Detached annexe.
4 Hatherleigh Gardens Bognor Regis

Thank you for your internet representation made on 1st February 2018 which has been recorded as '**an objection**' with the comments as follows:

block plan

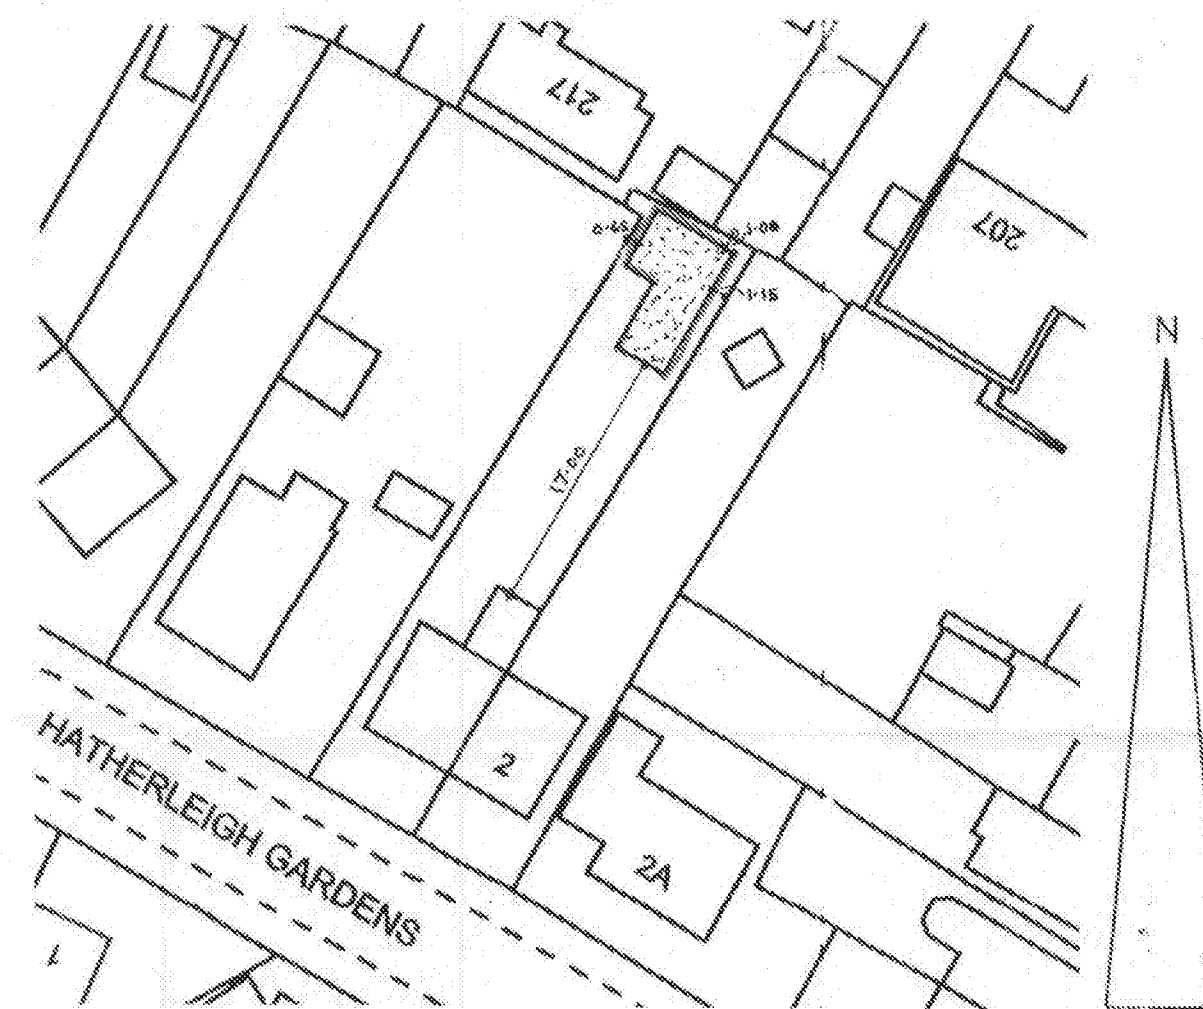
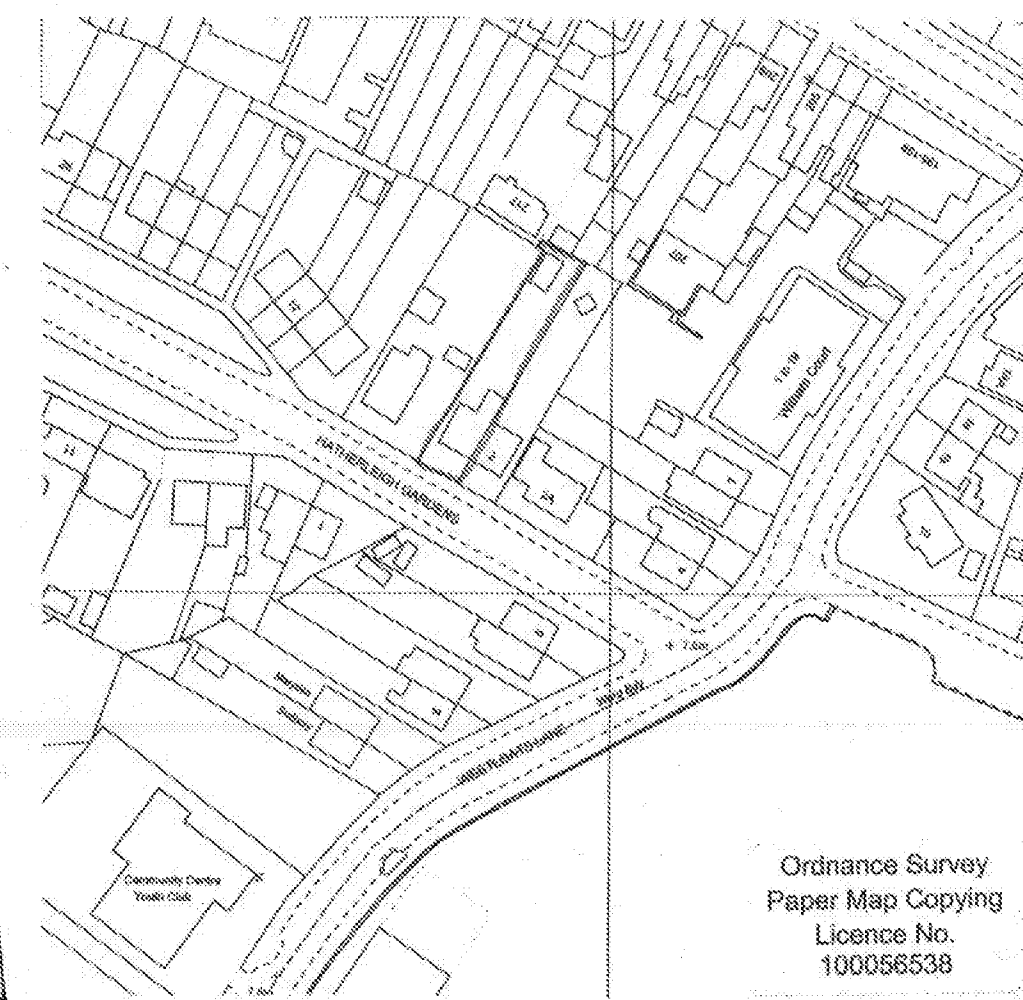
I am concerned that their guttering is hanging over my boundary line. My house's ground level is considerably lower than Hatherleigh gardens and any problems with the guttering of this new build would have a significant impact on my property - flooding.

We showed our concerns to the builders who assured us that it would not overlap the boundary and that it had all the planning permission needed
